EL PASO COUNTY STORMWATER MANAGEMENT PLAN CHECKLIST

Revised 5/21/07

FIGURE A1

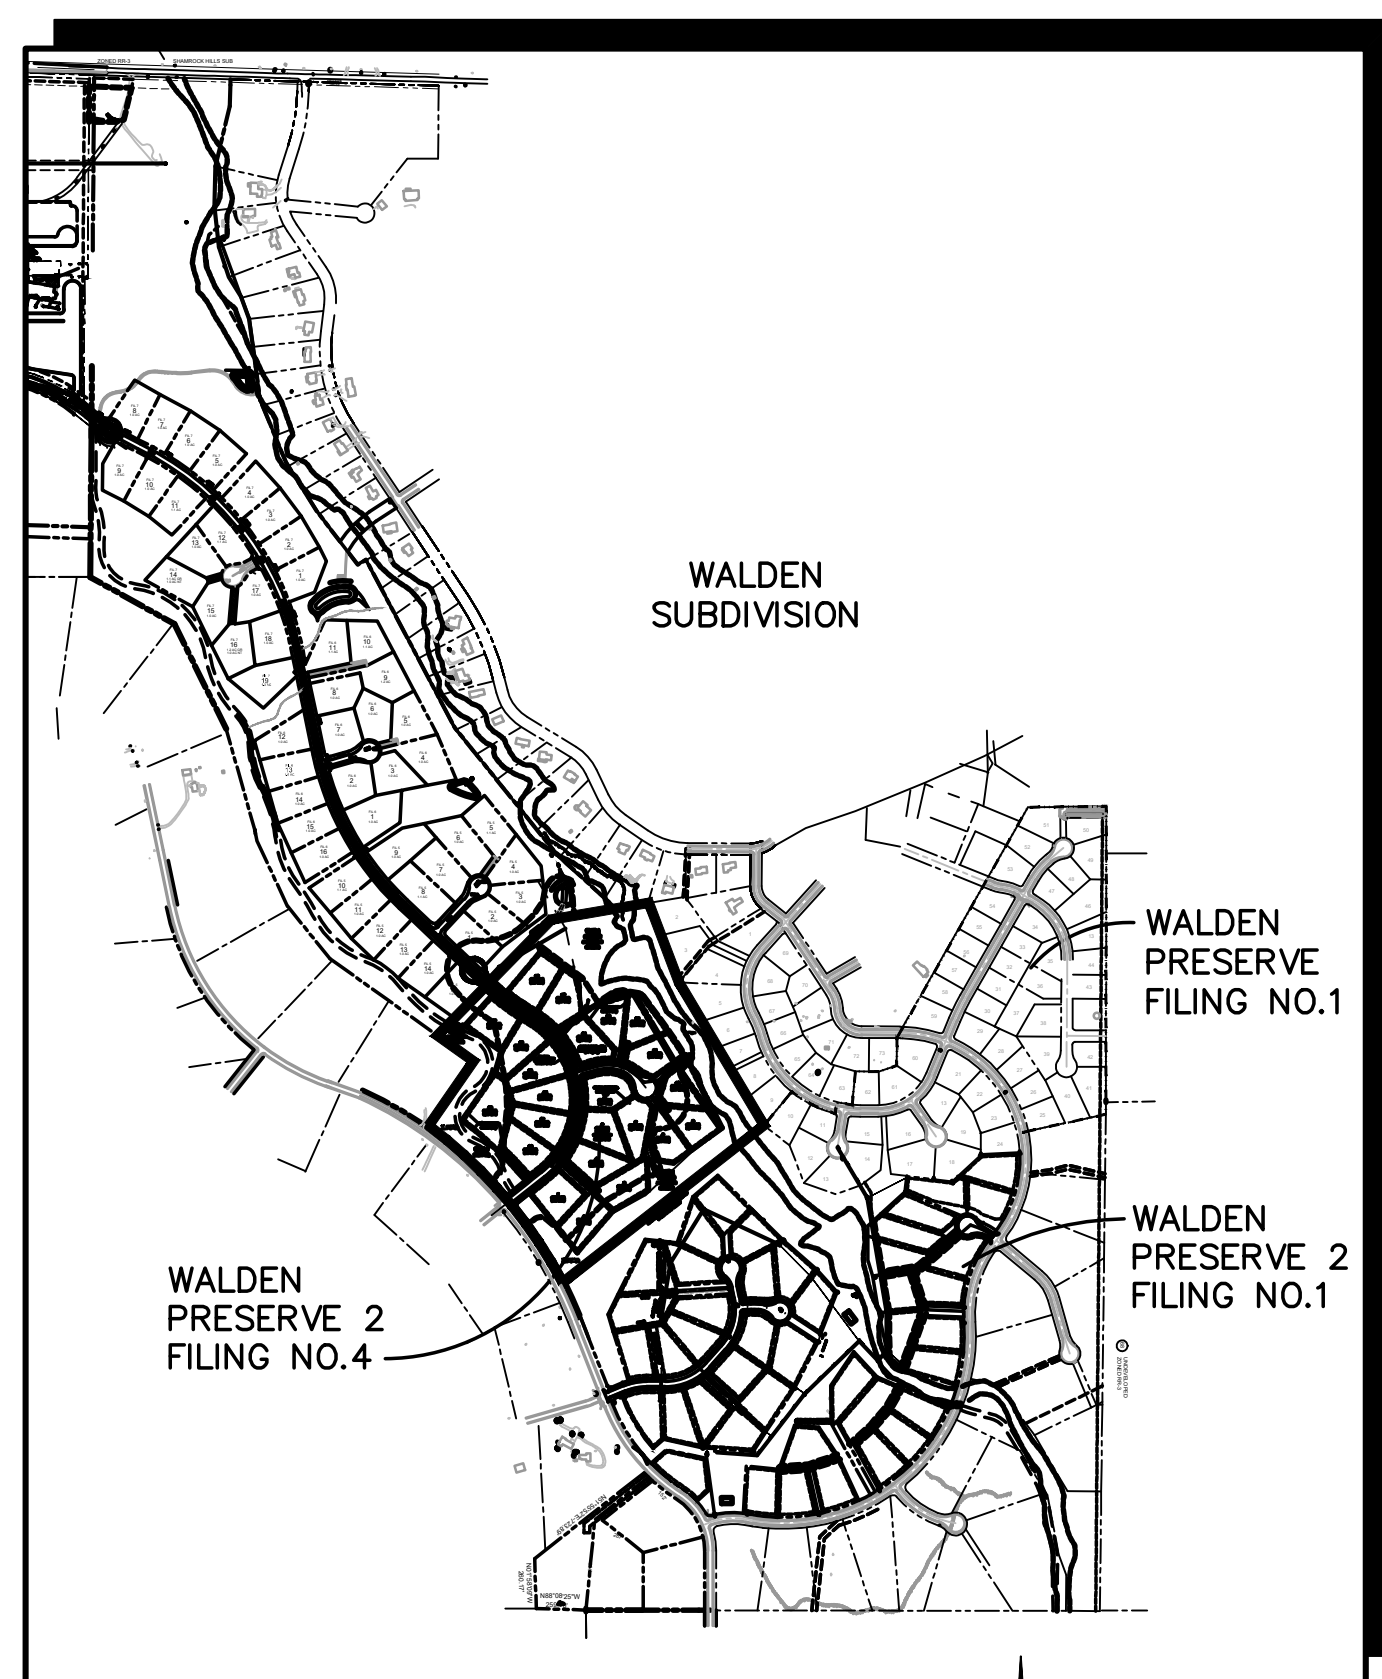
3) Site description and location to include vicinity map (not just Section, Township, Range)

Unresolved - dsdlaforce
06/19/2019 7:53:33 AM

SHEET: **C1.2**

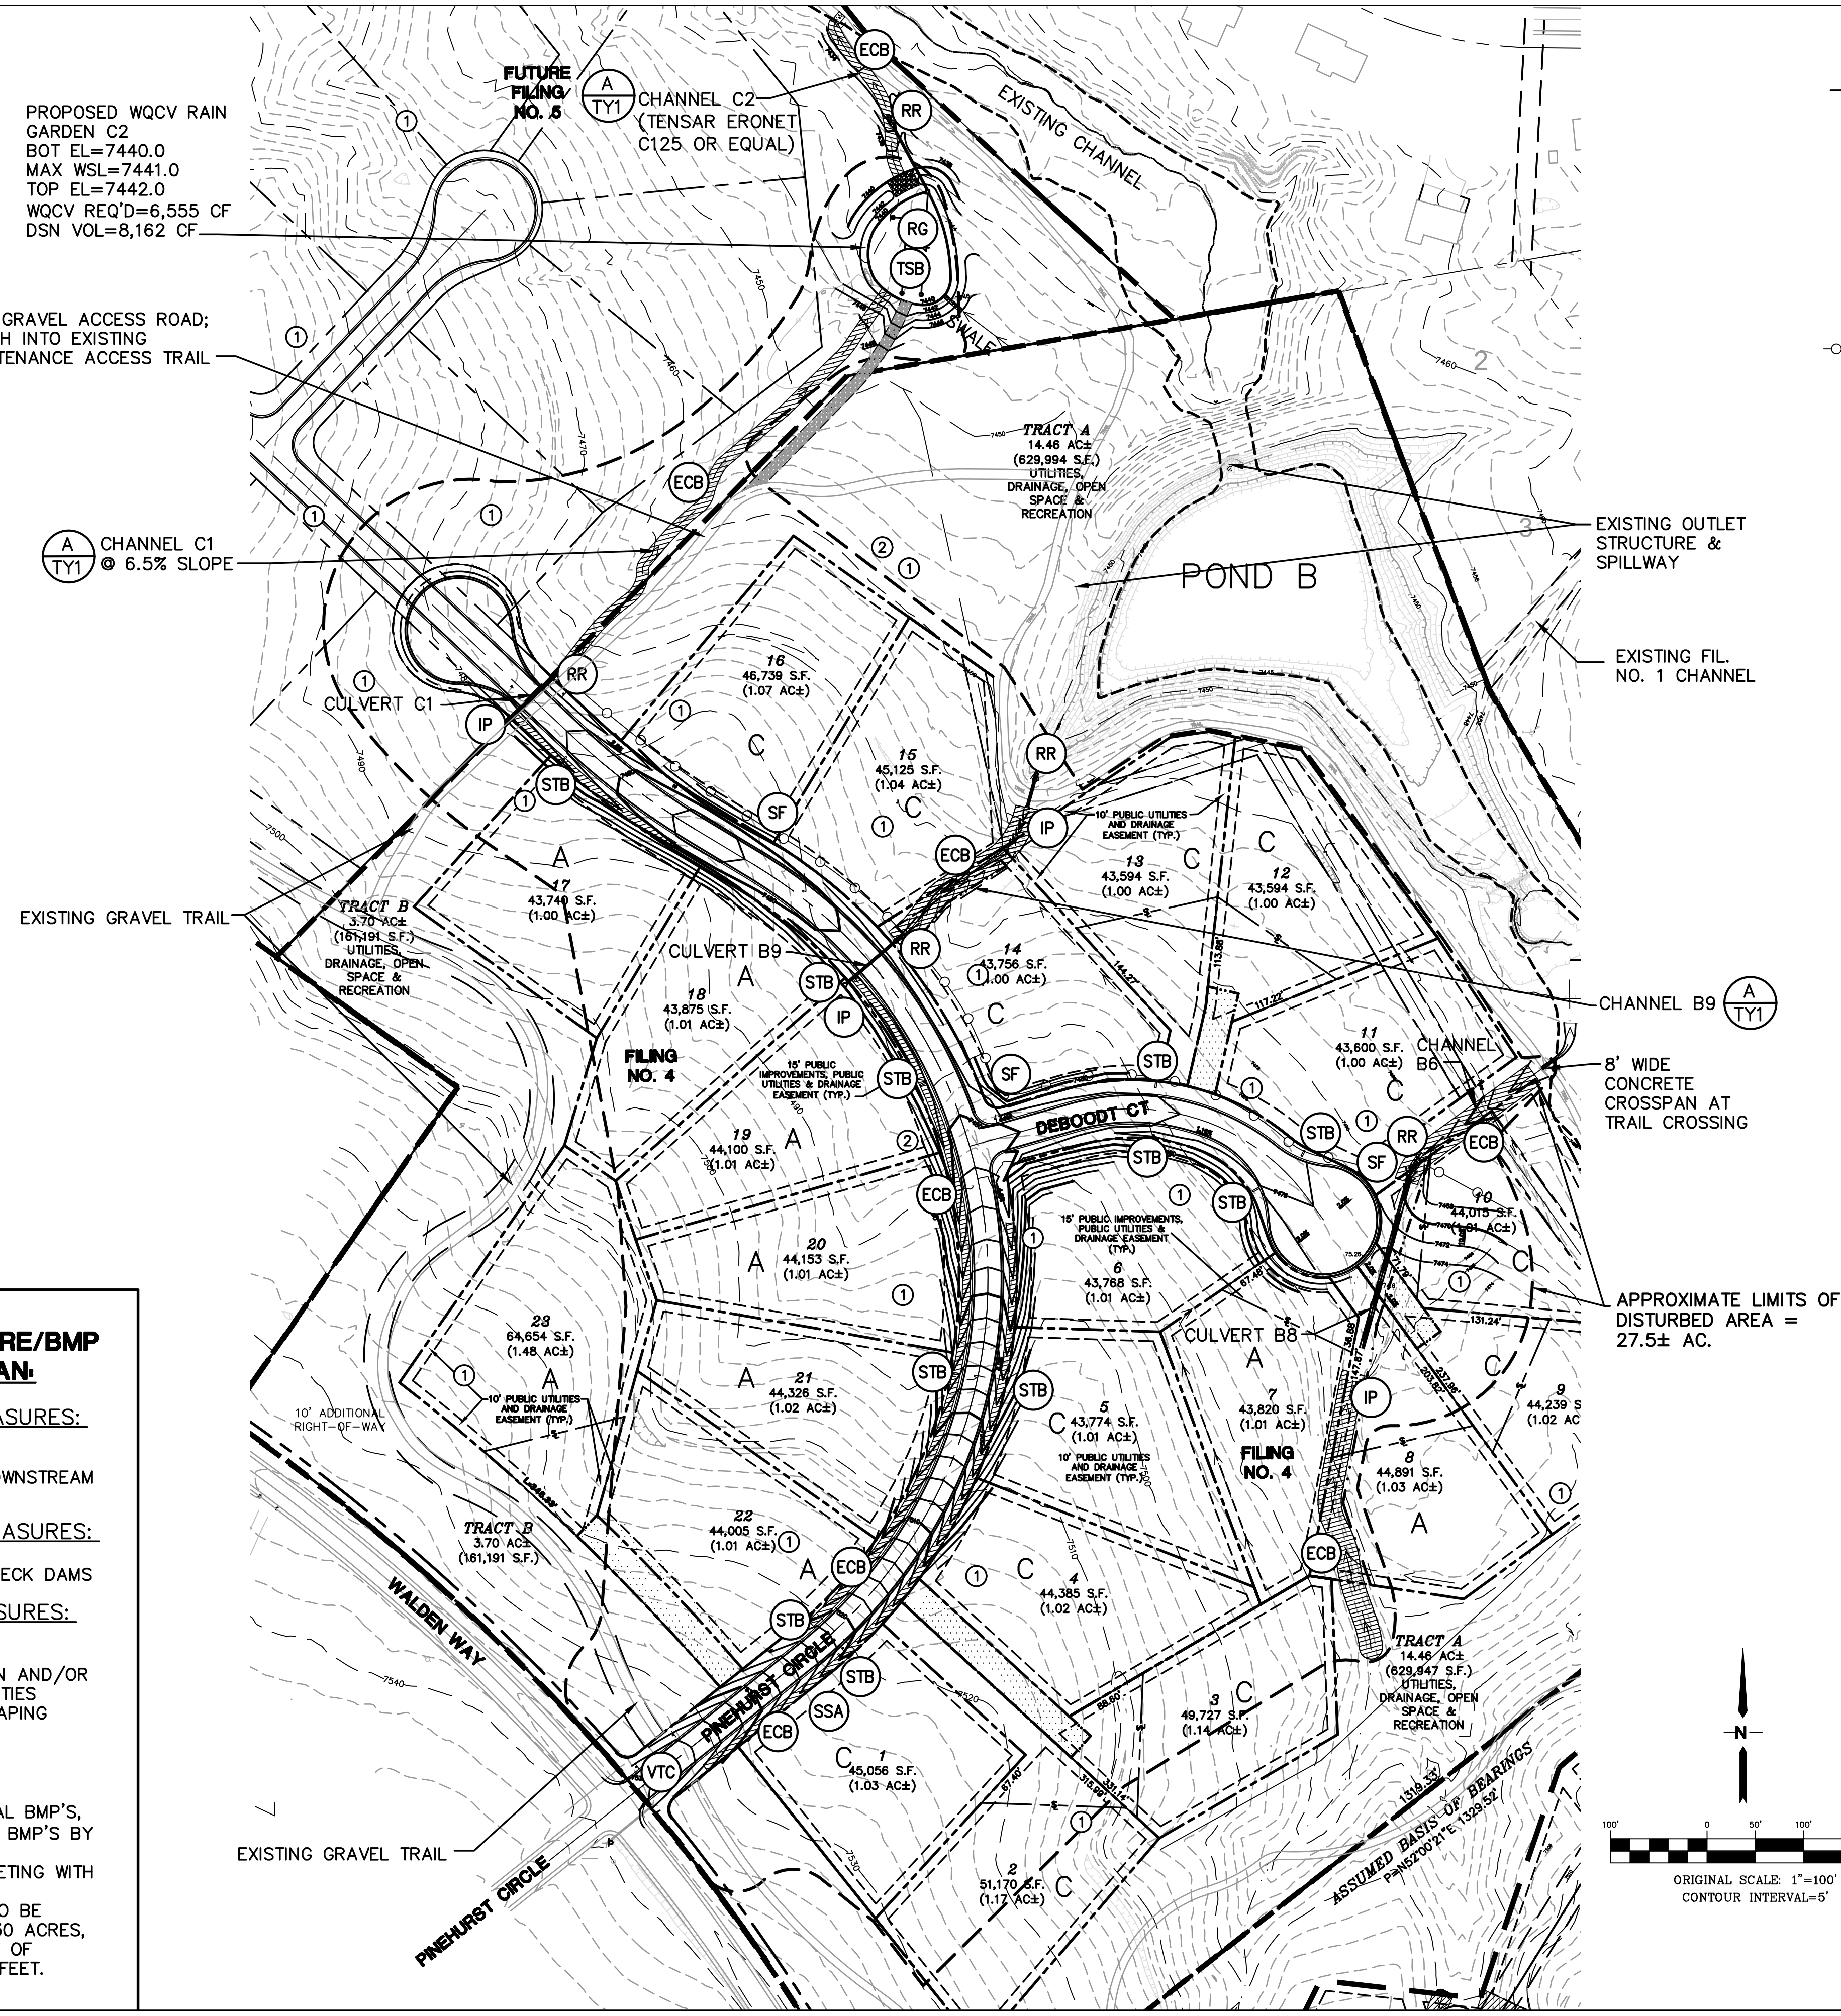
17) SWMP Map to include:

Unresolved - dsdlaforce
06/19/2019 8:05:44 AM

a) construction boundaries

b) all areas of disturbance

c) areas of cut and fill

d) areas used for storage of building materials, soils or wastes (stockpiles)

e) location of any dedicated asphalt / concrete batch plants

f) major erosion control facilities or structures (sedimentation ponds, etc.)

g) springs, streams, wetlands and other surface waters

h) boundaries of FEMA mapped 100 year flood plain
